1720/04-190202
PP-07644073

Application under Section 73 of the Town and County Planning Act 1990 for variation of Condition 1 of A/81/18/RES at Quiet Waters, Roundstone Lane, Angmering, BN16 4AX

Condition 1 relates to the approved plans, this application seeks permission for a number of minor changes to the layout and changes to the elevation of the apartment block to improve the overall quality of the development.

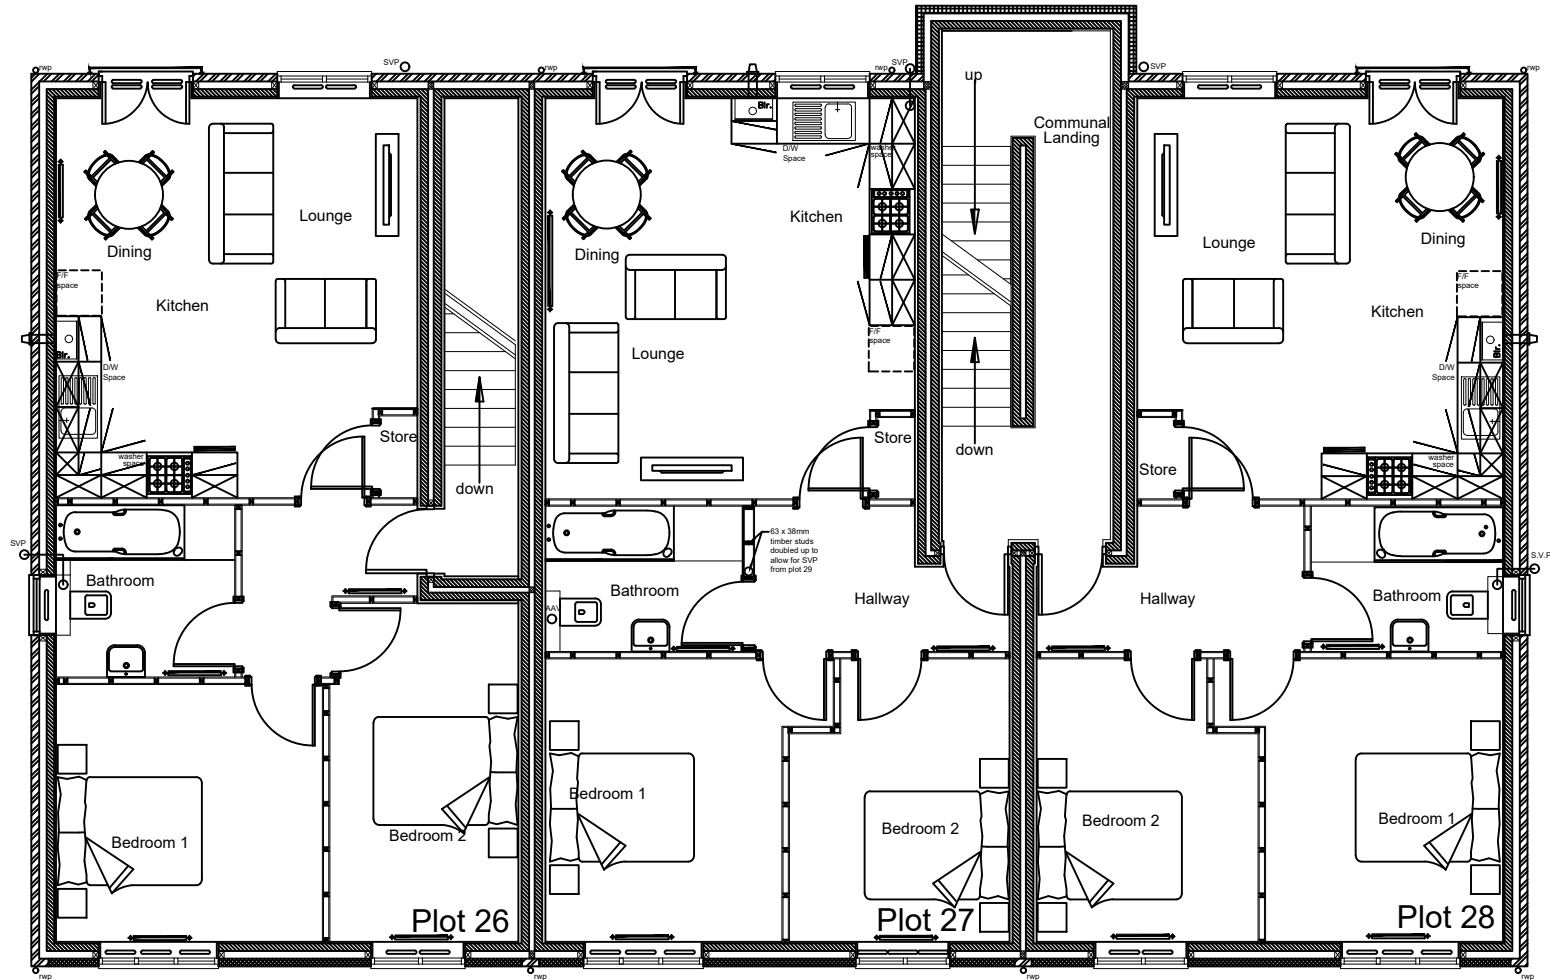
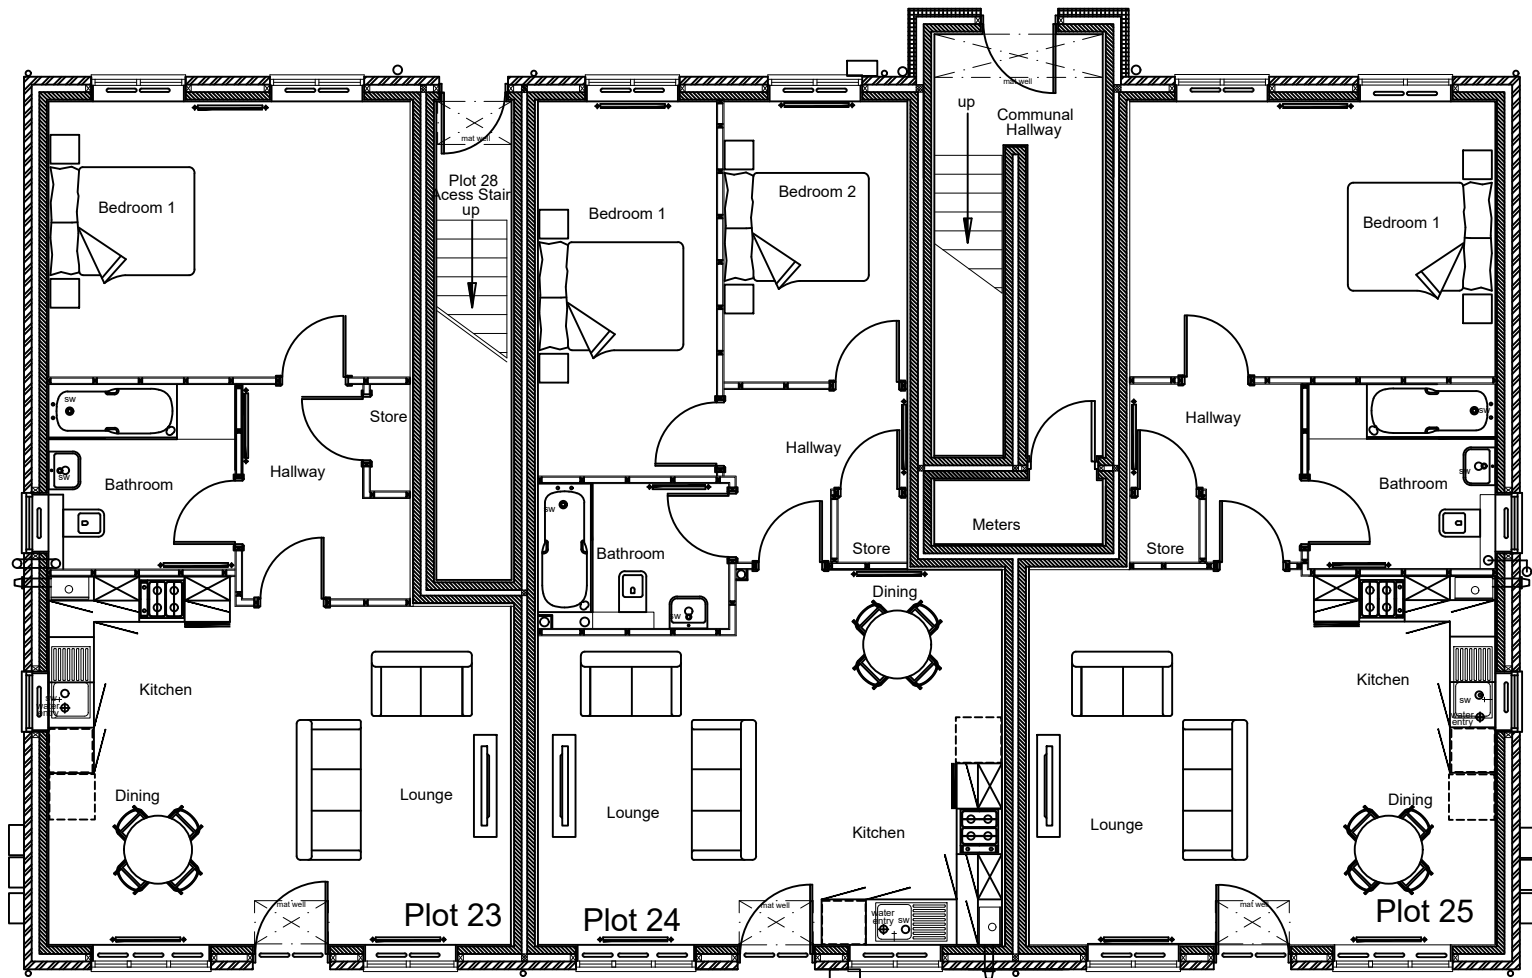
10. **Amendment to Apartment Block Rear Elevation** – The rear elevation of the apartment block has been amended to omit the dormer window at second floor level. Instead the roof now extends down to below the eaves of the first storey level. The dormer was above the communal stairs with an area of ‘dead-space’ where the landing did not lead to anywhere. This area of ‘dead-space’ has now been omitted and closed off. The omission of the dormer window will reduce the overall bulk of the apartment block and improve the overall appearance of the building. These changes are show on the following plans:

- 1006-Ang110 Rev. D - Apartments Ground and First Floor
 - 1006-Ang111 Rev. D - Apartments Second Floor and Roof Plan
 - 1006-Ang112 Rev. D - Apartments Front and Side Elevations

Project. Angmering		
Title. Proposed site Layout		
Construction		
Scales. 1:200@A1		Date. May 2018
Drawing Number. 1006-Ang101	Revision. R	Drawn by. PM

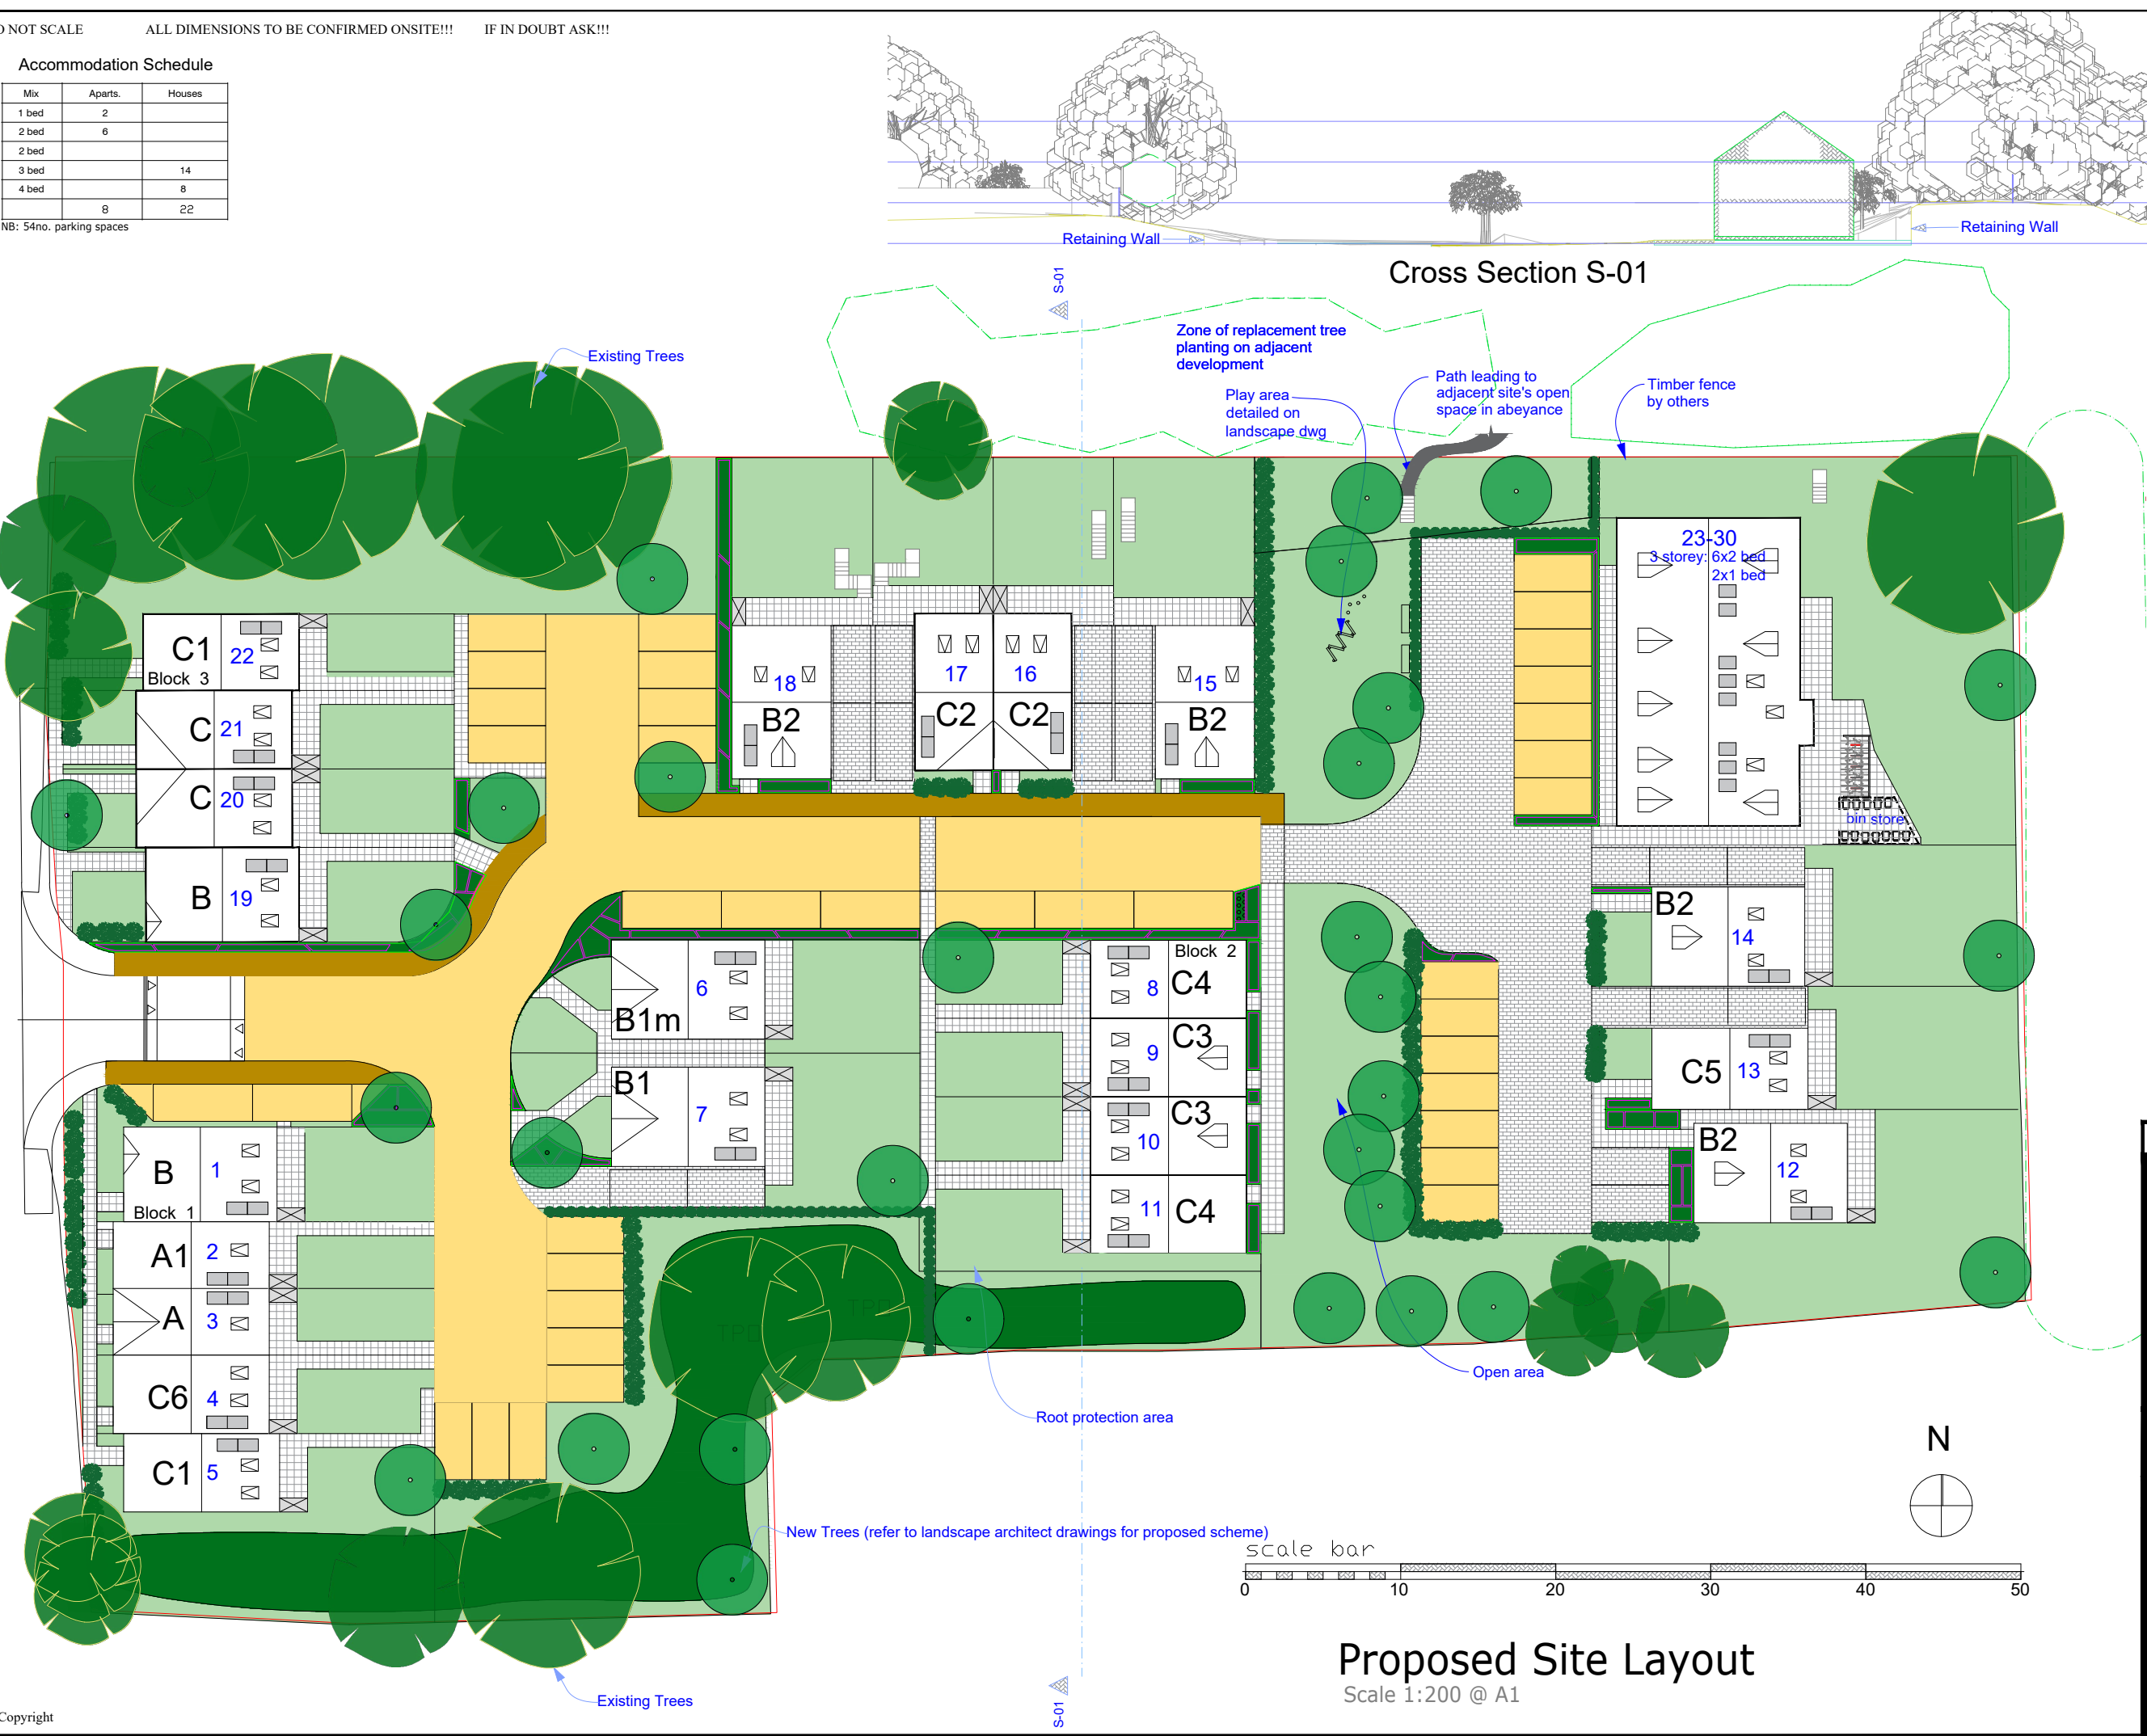
1. **Kerb-line Realigned** – The kerb has been marginally re-aligned in on the access road between P19 and P6. Previously the footpath was too narrow in this part of the site;
2. **Footpath Along Frontage** – A footpath has been included at the frontage of the site along Roundstone Lane at the request of the Highways Authority;

3. **Additional Fencing and Lockable Gates** – Additional fencing has been added to delineate between the plots. This is generally in the rear gardens of the plots.

4. **Footpath Material Change** – The footpath which lines the access road has been changed from paving slabs to tarmac. Paving slabs were proposed erroneously when the materials condition was discharged. Tarmac is a much more appropriate material for the paths;

5. **Fire Hydrants** – The fire hydrant has been relocated towards the middle of the site at the request of the Fire Brigade and Southern Water;
6. **Plot 11** – The path to the front P11 has been shortened as it did not lead to anywhere;

8. **Plot 12 Turning Area** – Road to the front of P12 has been extended southwards by 500mm to enable better turning provision;
9. **Hedge Planting** – Additional hedge planting is proposed across the site;
